A Minor Amendment to a Site Development Plan for Building Permit approved prior to the effective date of the IDO to for minor changes to the exterior of the building including a new front entry, new colors and roof, mural, updated signs

RE: 5021 Pan American Fwy NE

RE: Administrative Amendment - Tula's Kitchen
Planning case file: 03EPC 01665 / Project# 1003009

REAR ELEVATION

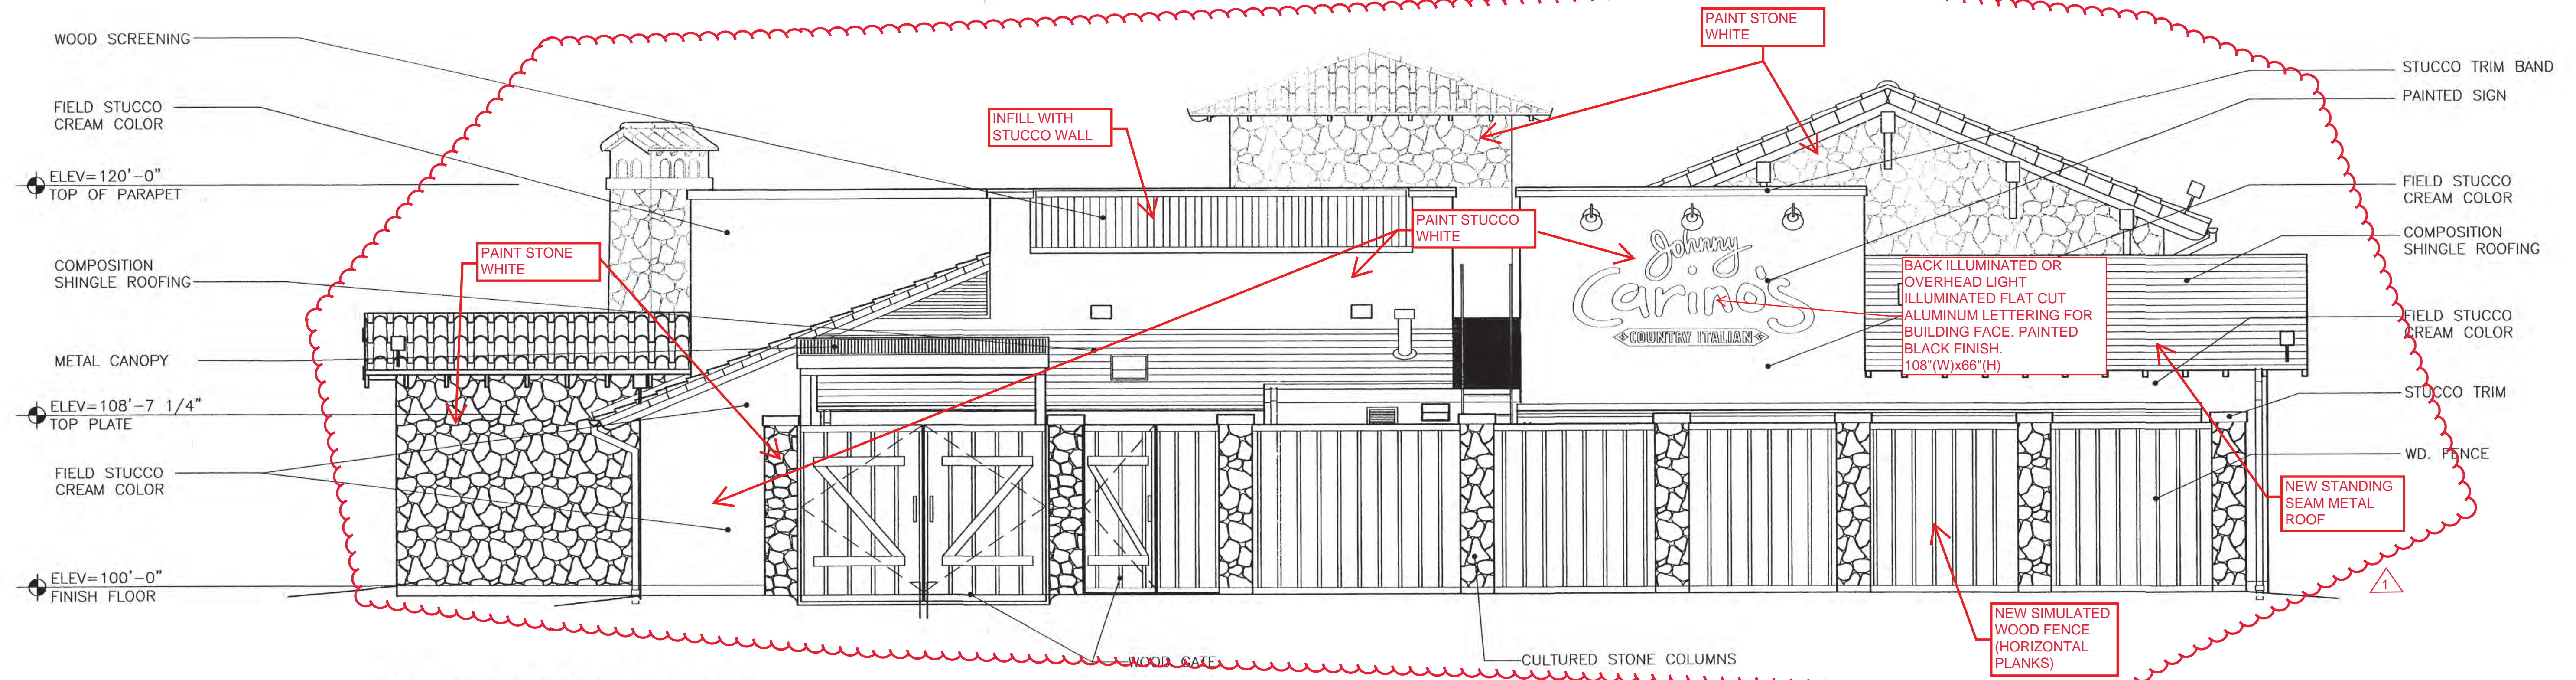
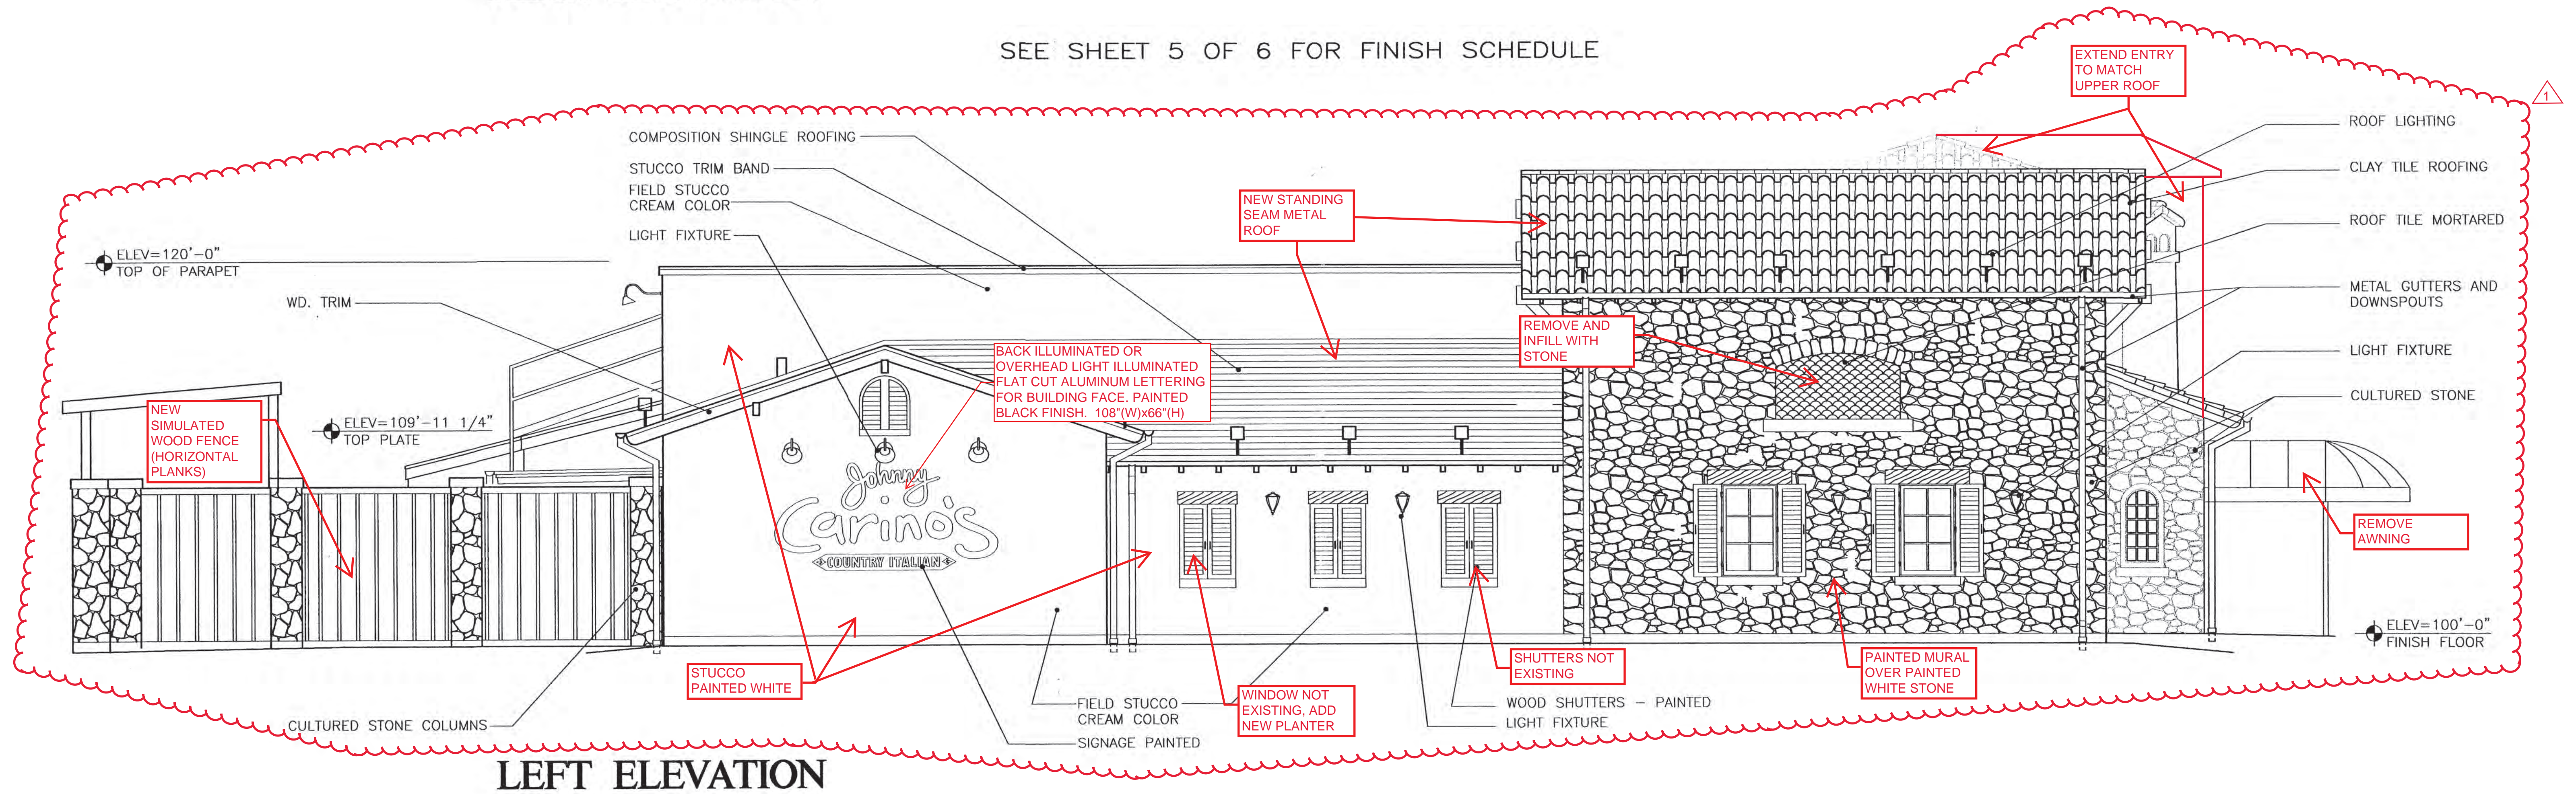
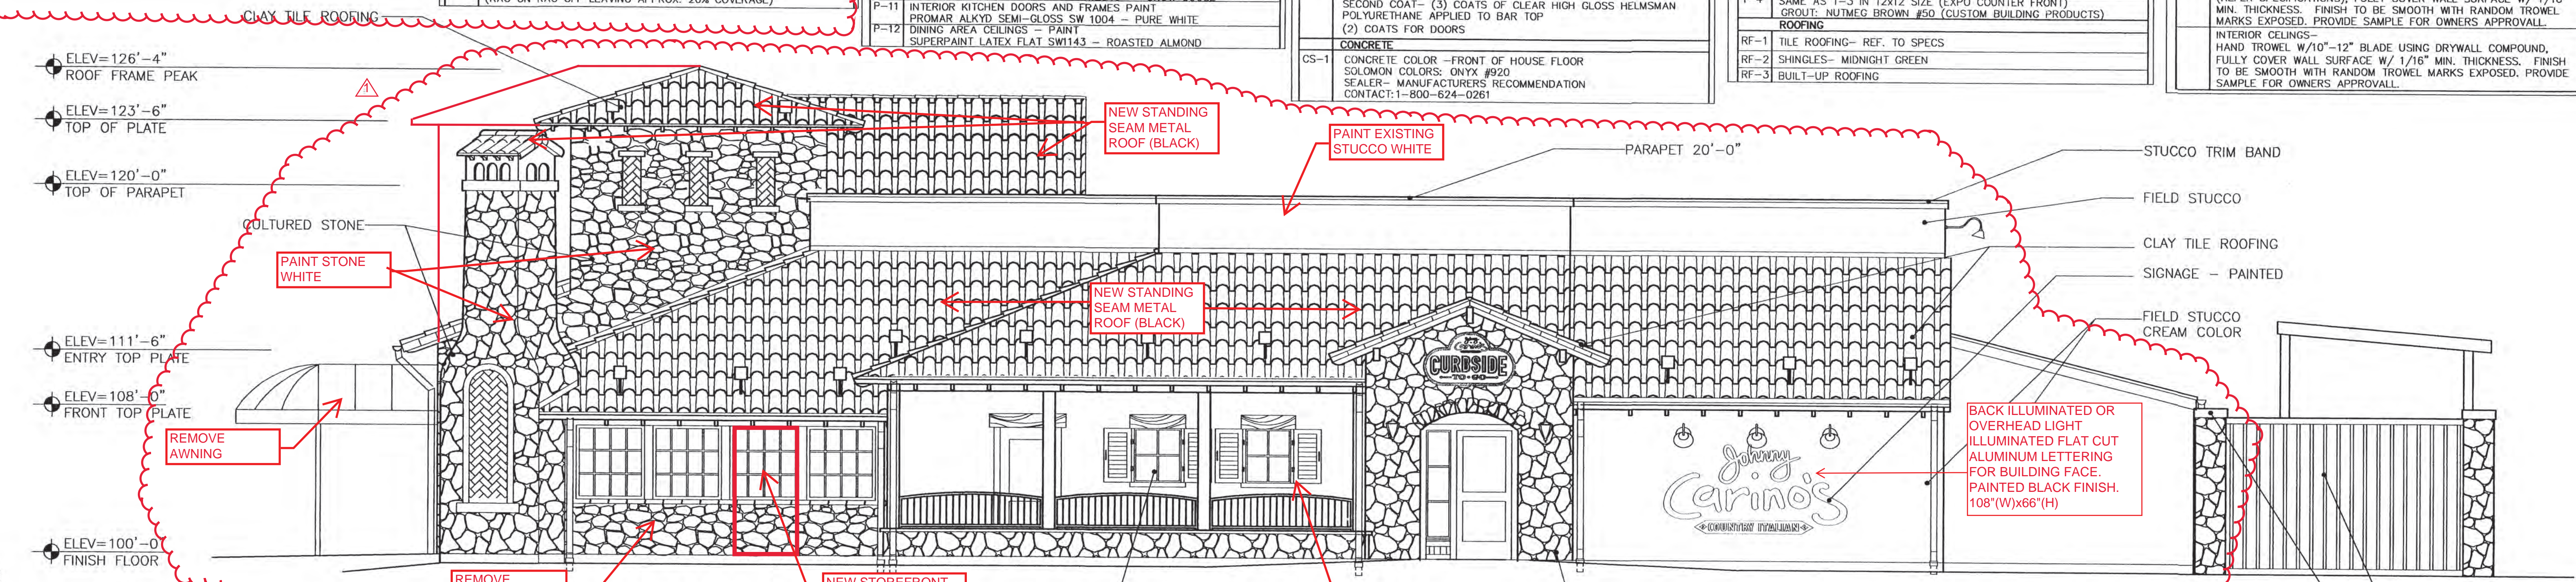
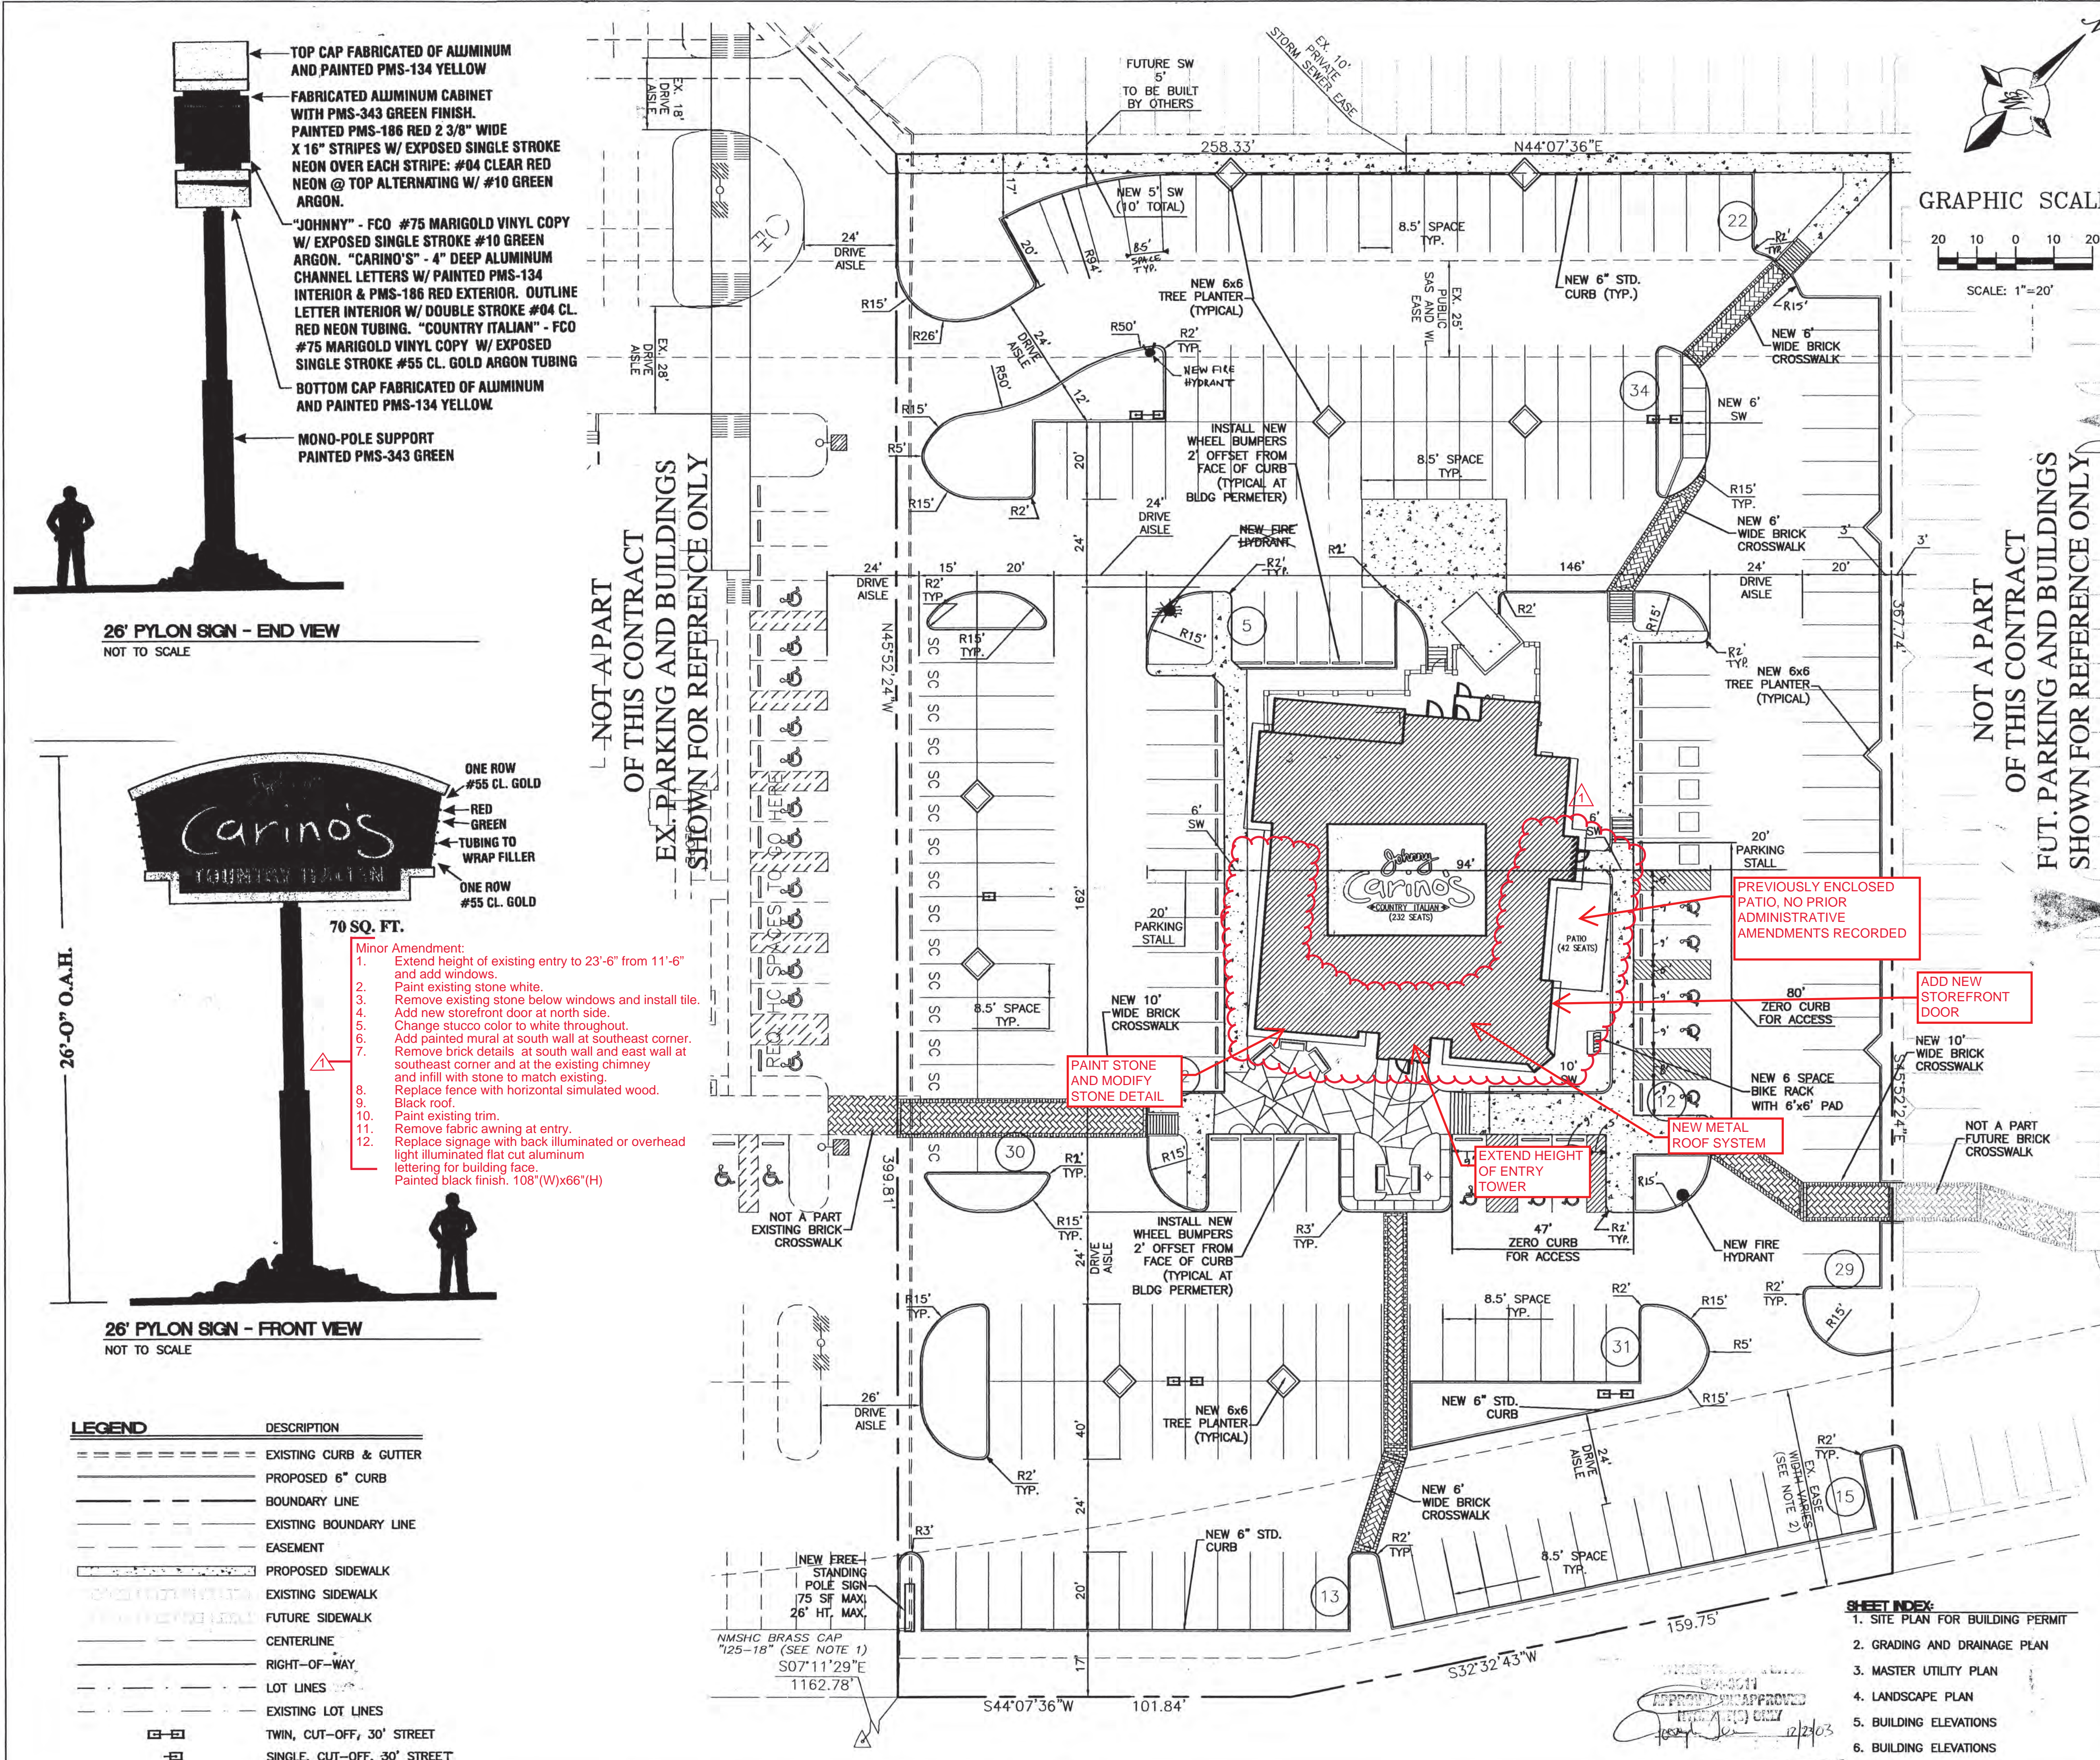
The requested changes for this amendment are listed in detail below and are also circled in red and noted on the prior approved **Jefferson Commons II- Site Plan for Building Permit**. It is the applicant's intent to incorporate changes to the building which are not in conflict with any of the regulations or other requirements of the approved Site Development Plan.

1. Extend height of existing entry to 23'-6" from 11'-6" and add windows to create a new decorative main entryway.
2. Paint existing stone white.
3. Remove existing stone below windows and install tile.
4. Add a new storefront door on the north side.
5. Change stucco color to white throughout.
6. Add painted mural at south wall at southeast corner.

7. Remove brick details at south wall and east wall at southeast corner and at the existing chimney and infill with stone to match existing.
8. Replace fence material with horizontal simulated wood.
9. Install new black metal standing seam roof.
10. Paint existing trim.
11. Remove fabric awning at entry.
12. Replace signage with non-illuminated flat cut aluminum building mounted lettering for building face with painted black finish.
